From: Adam Humphrey [REDACTED]
Sent: 16 July 2019 06:46
To: Sian Eggington
Subject: Re: Further Information Required on Your Ref: PP-07979086 Our Ref: P/64/19/HH
Categories: Green Category

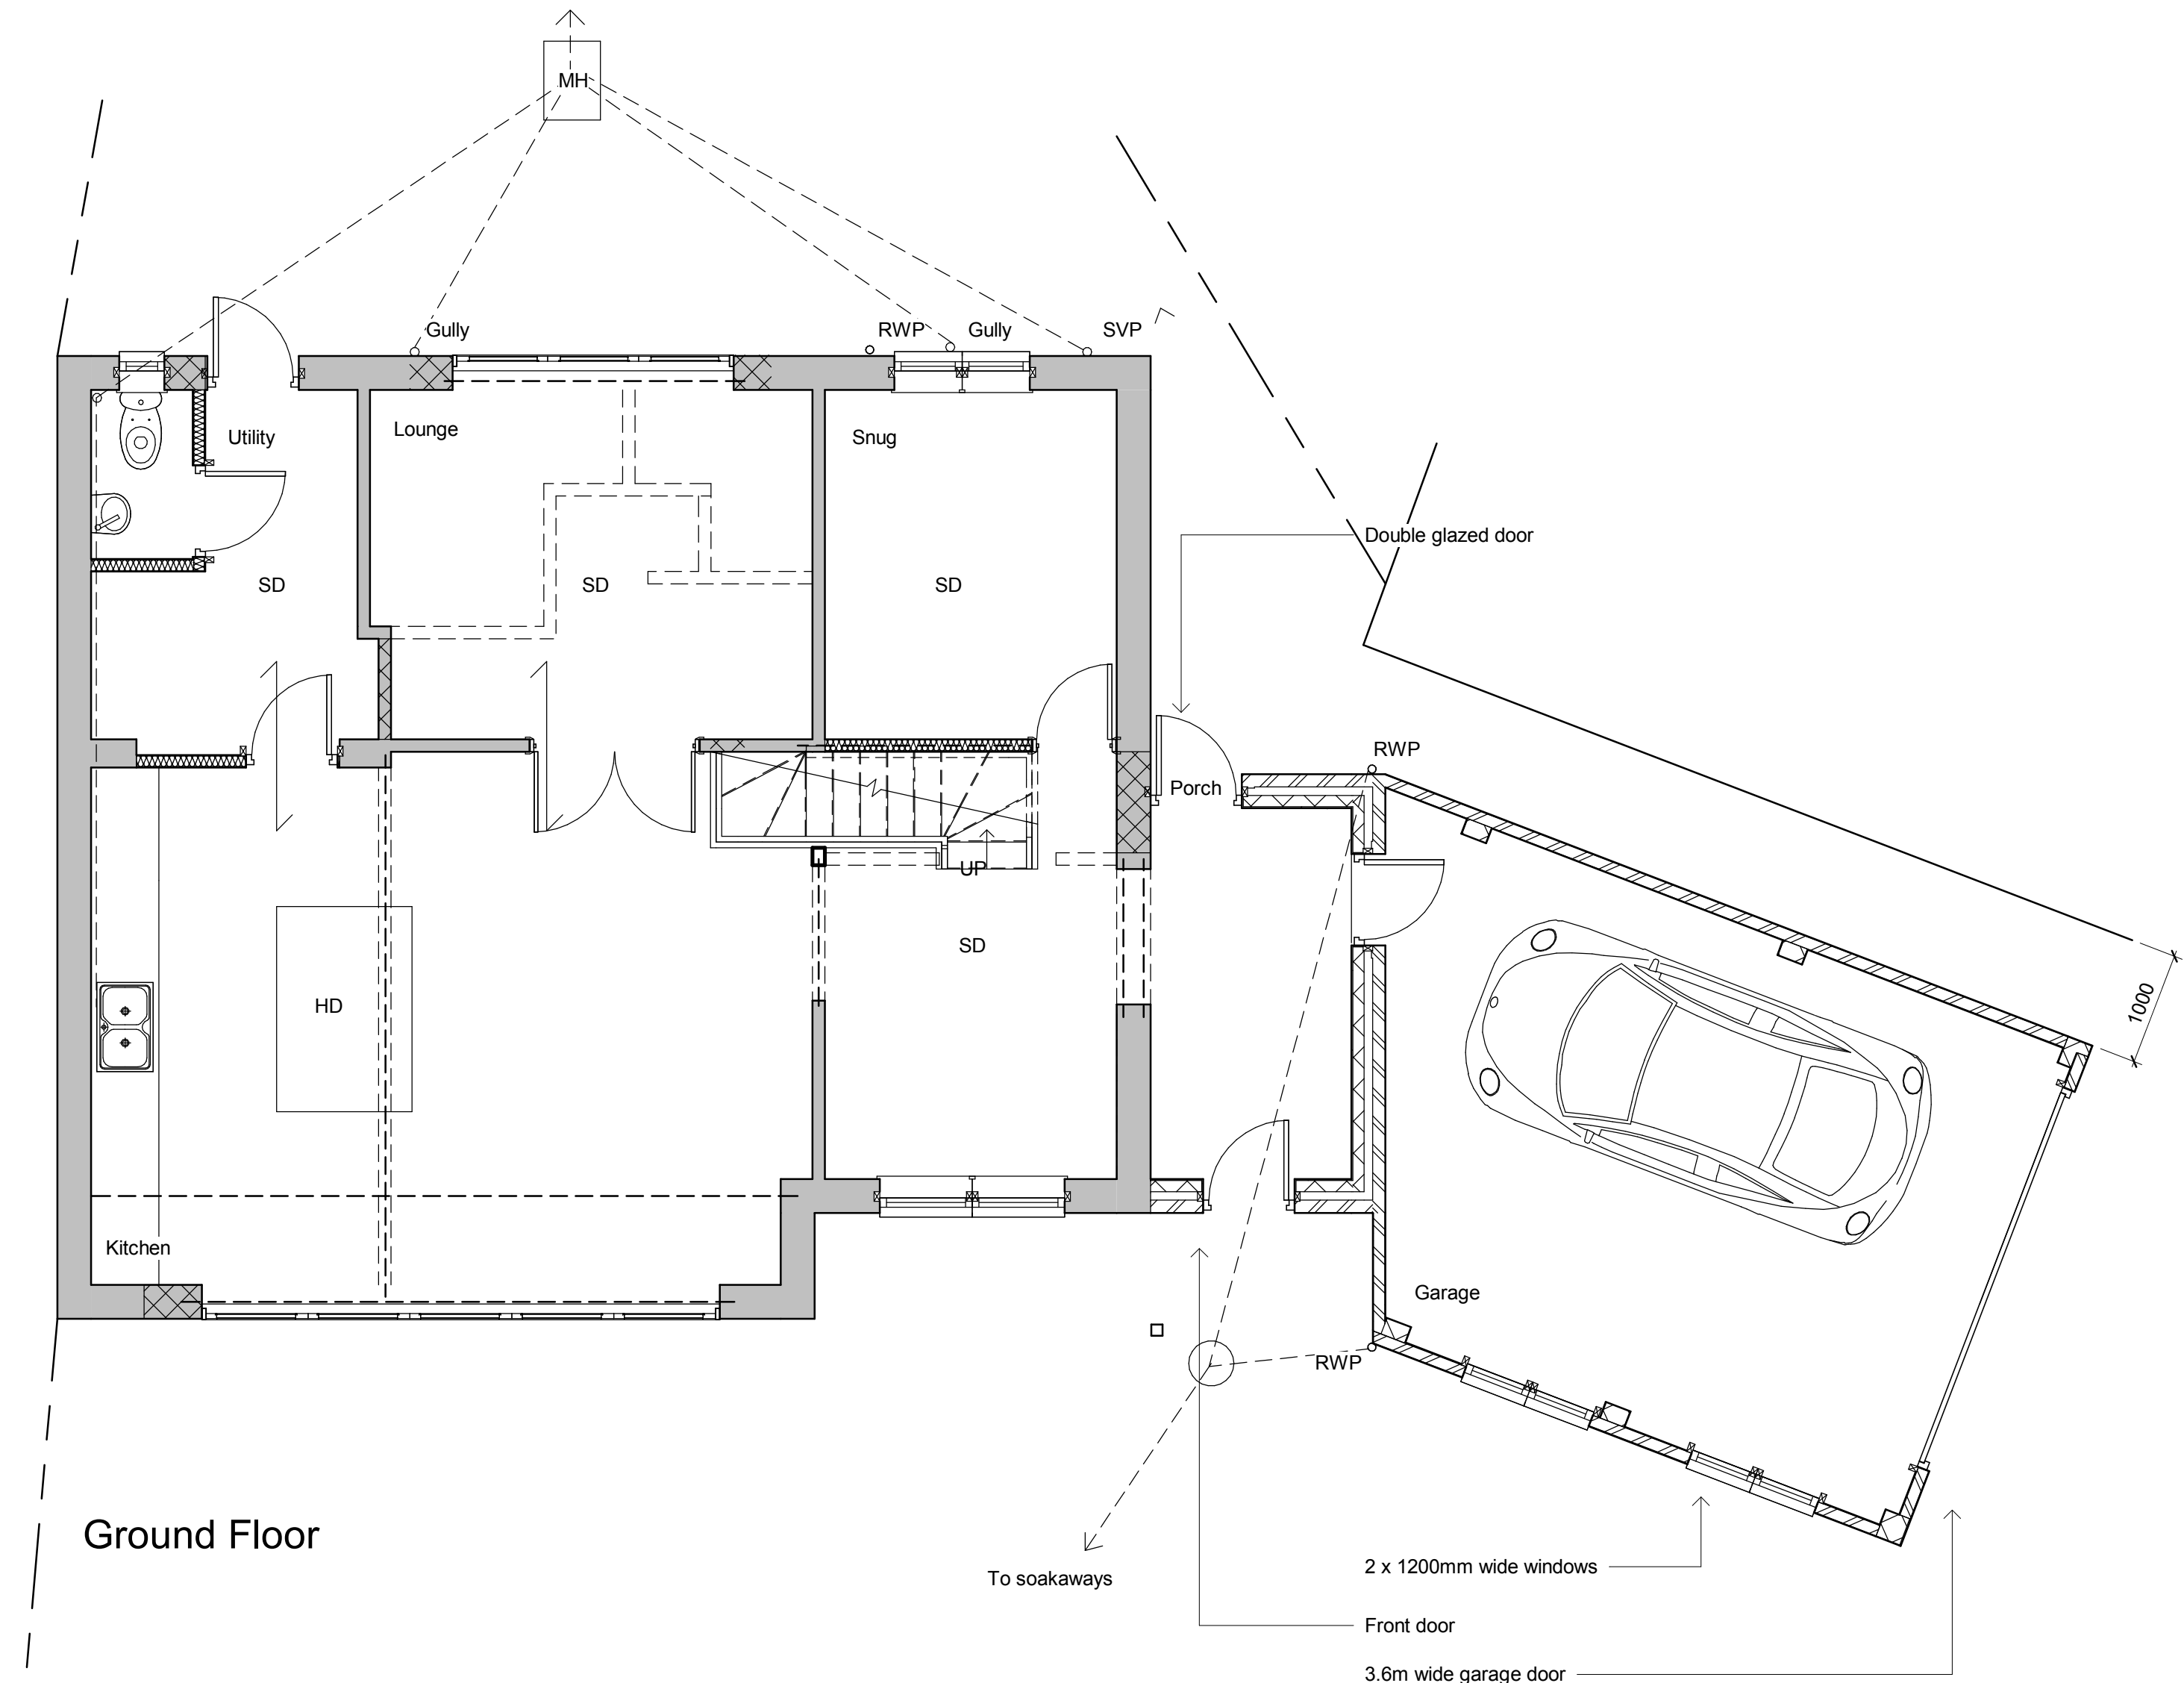
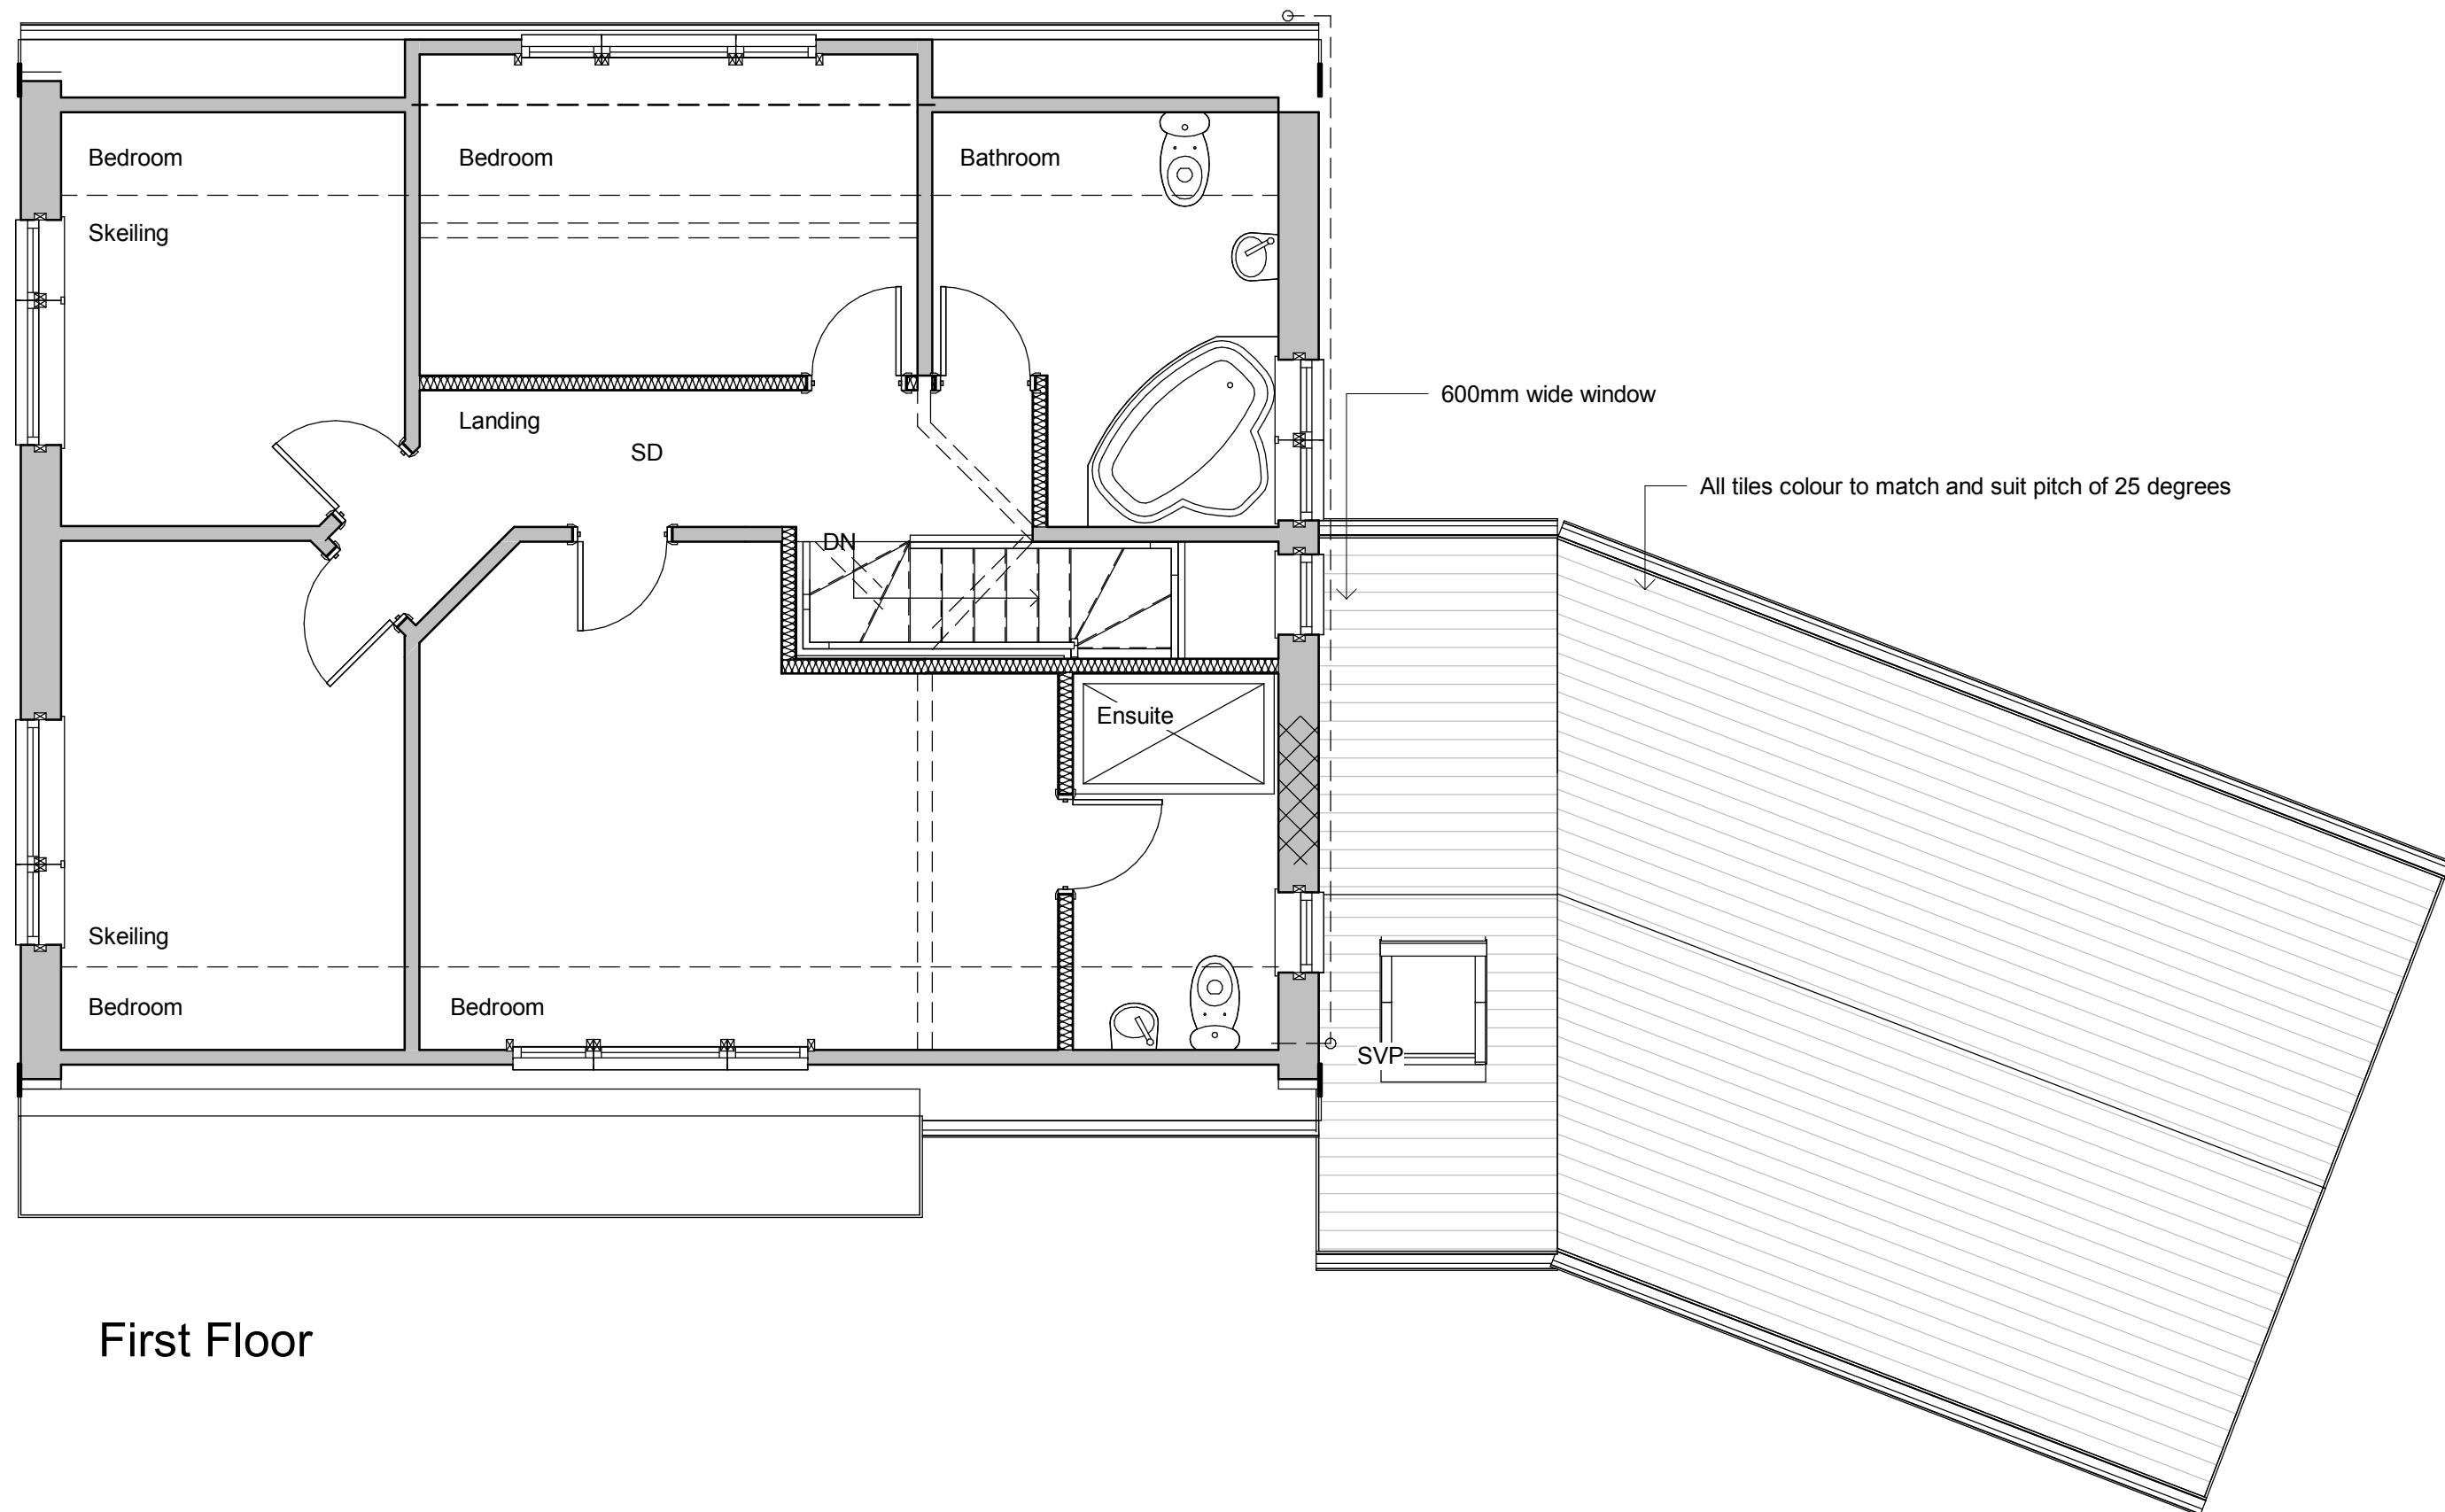
Thank you for your email, however dimensions are required to the front, rear and other side boundary. With your permission I can add these for you.

Yes feel free to add what you require.
